Please see below a list of adjustments we have made following the previous planning application submitted. We have addressed the concerns of the neighbouring properties as well as the planning officer. Below we have outlined the adjustments we have made to the overall proposal to address these points which we consider to be much more favourable to the planning office.

Adjustments we have made to address the points of the planning officer and comments of the neighbours

**PROPOSED
PLANS &
ELEVATIONS**

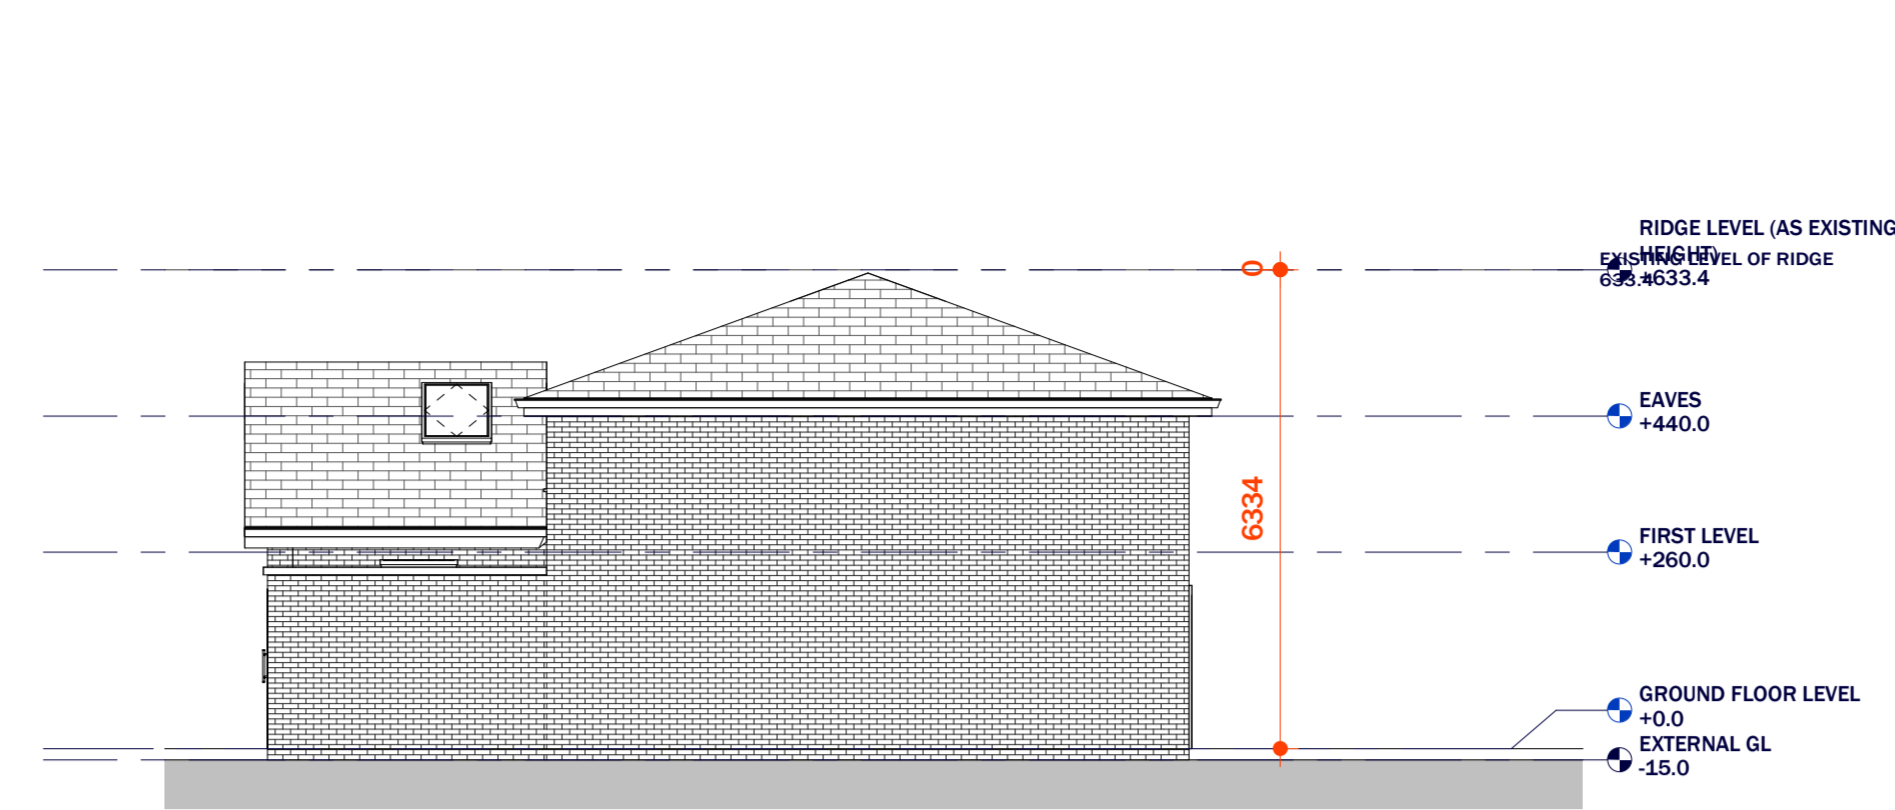
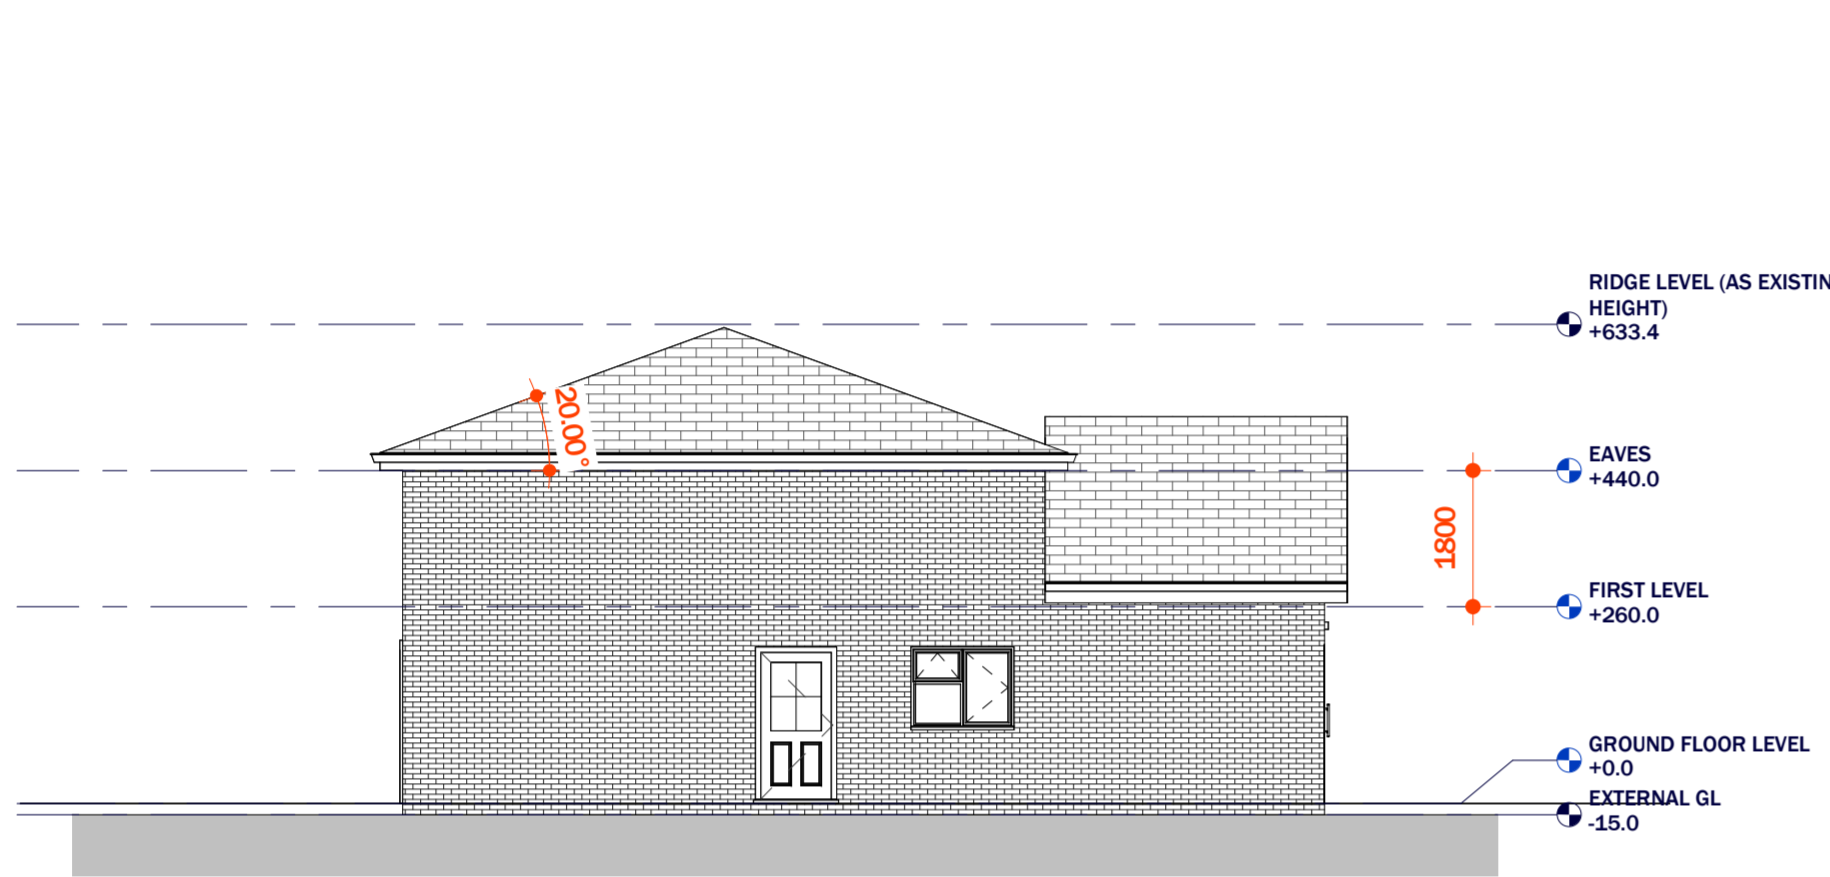
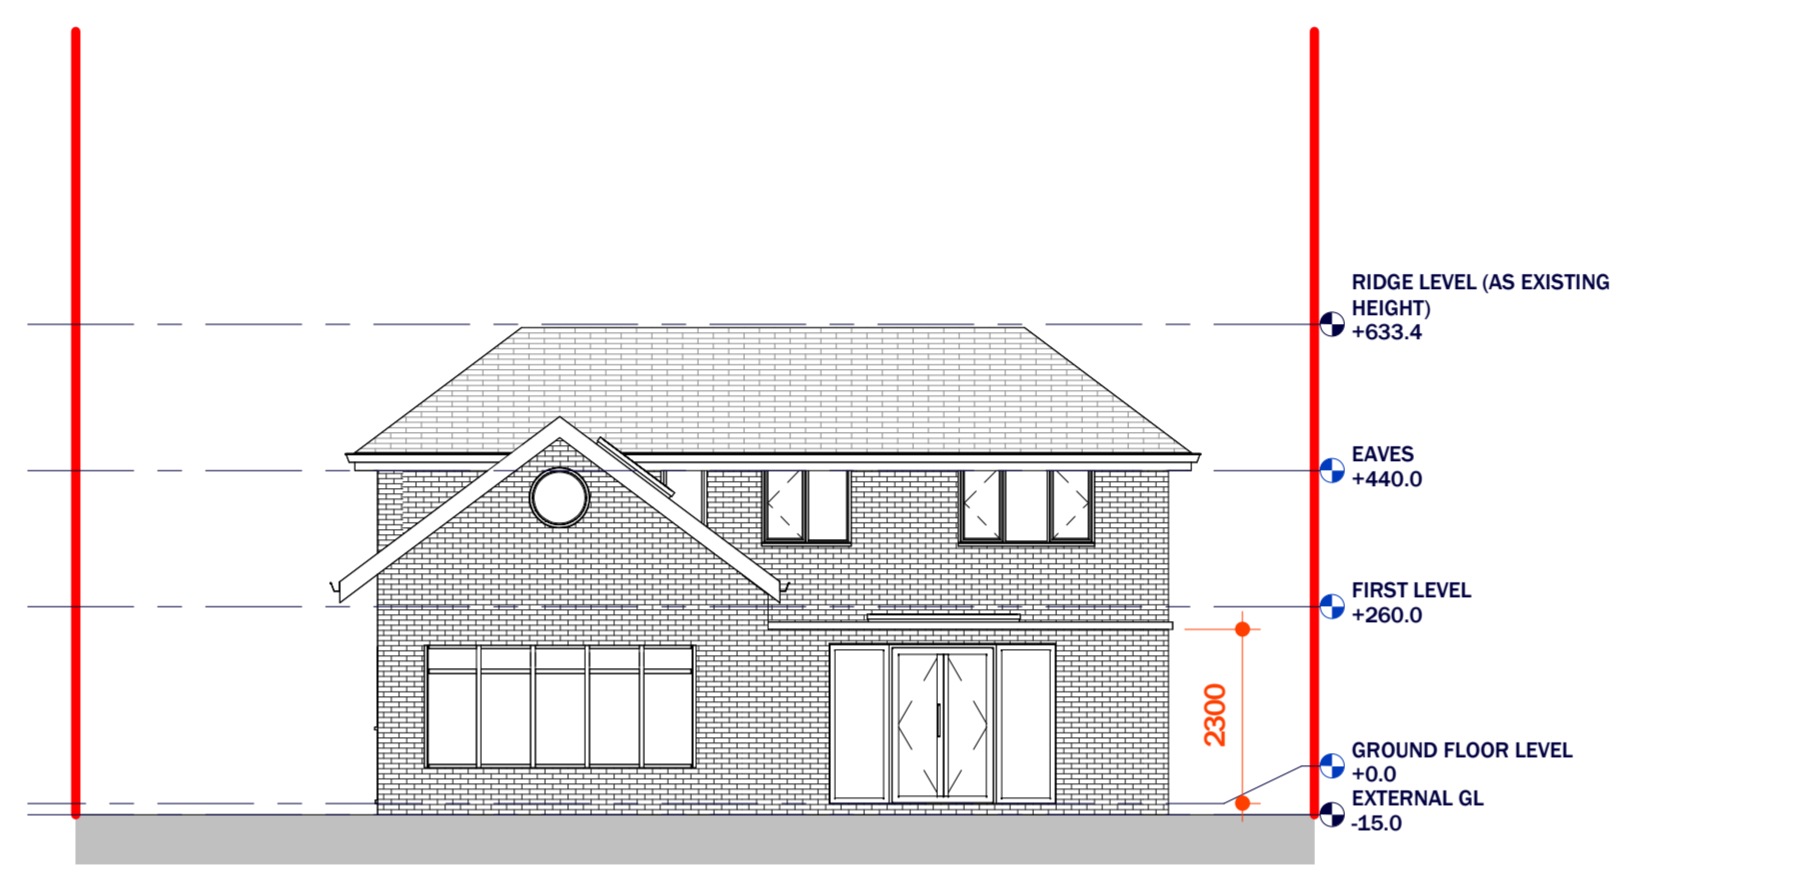
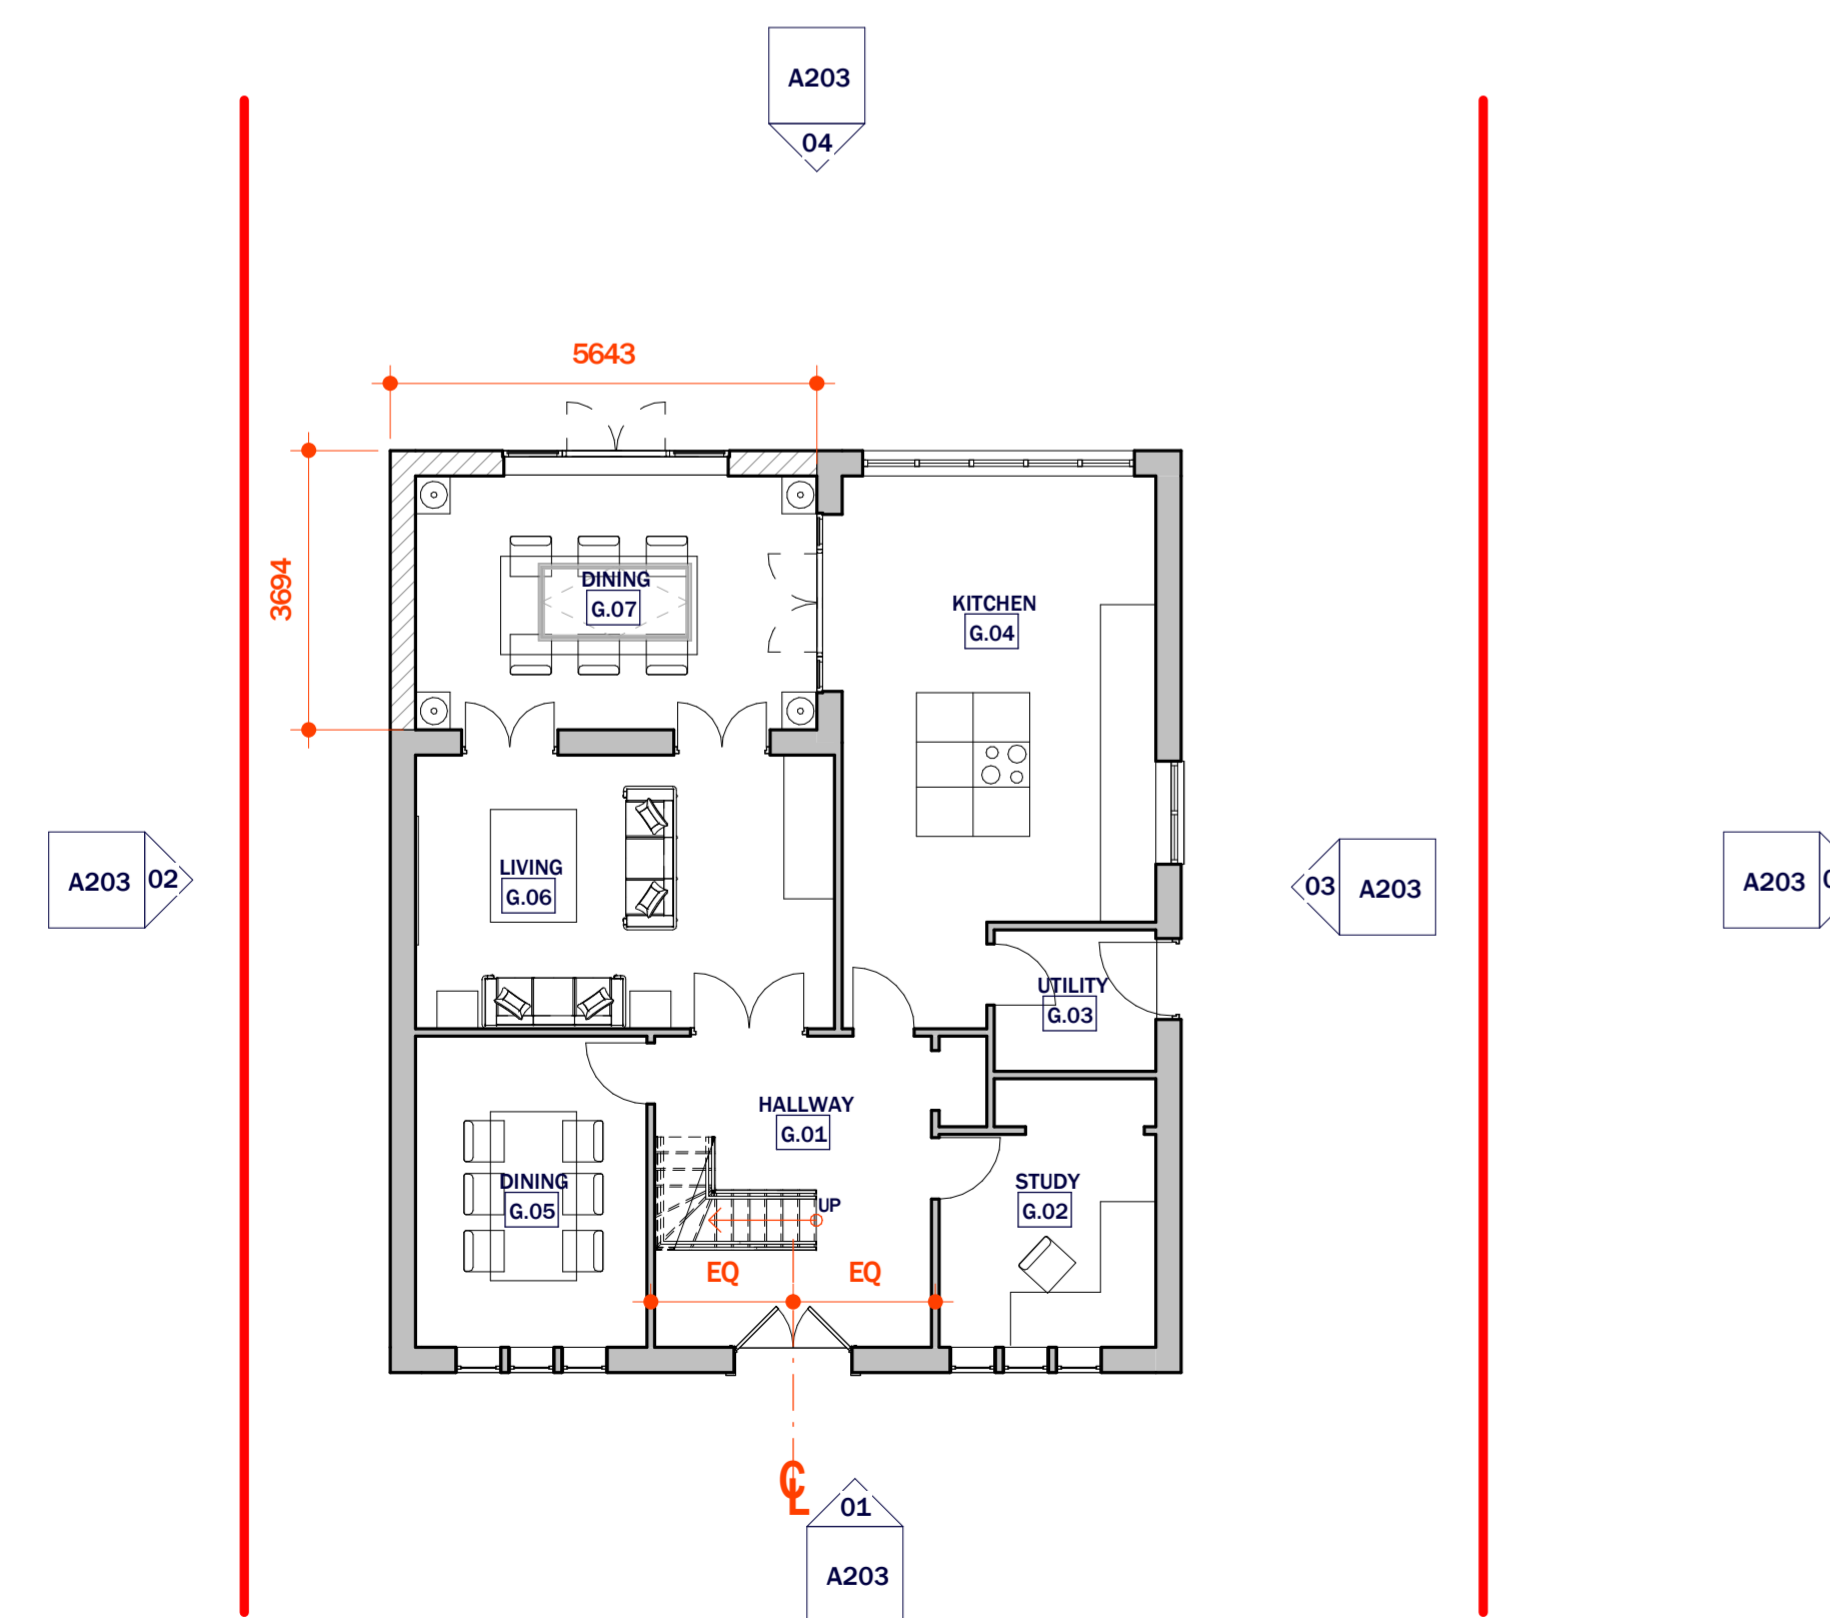
1. Reduce the ridge height so that it matches the existing ridge height (Achieved by a combination of the below adjustments)
2. Reduce the eaves height from the previous proposal
3. Removed the side master bedroom window - a point by your neighbour - We have added a smaller window facing the rear garden
4. Reduce the pitch angle of the roof to 20 degrees
5. Reduced the size/height of the first-floor windows to 1100mm
6. Reduced the level of the first-floor window cill heights to 700mm - Still allowing for a generous size window to push light into the bedrooms
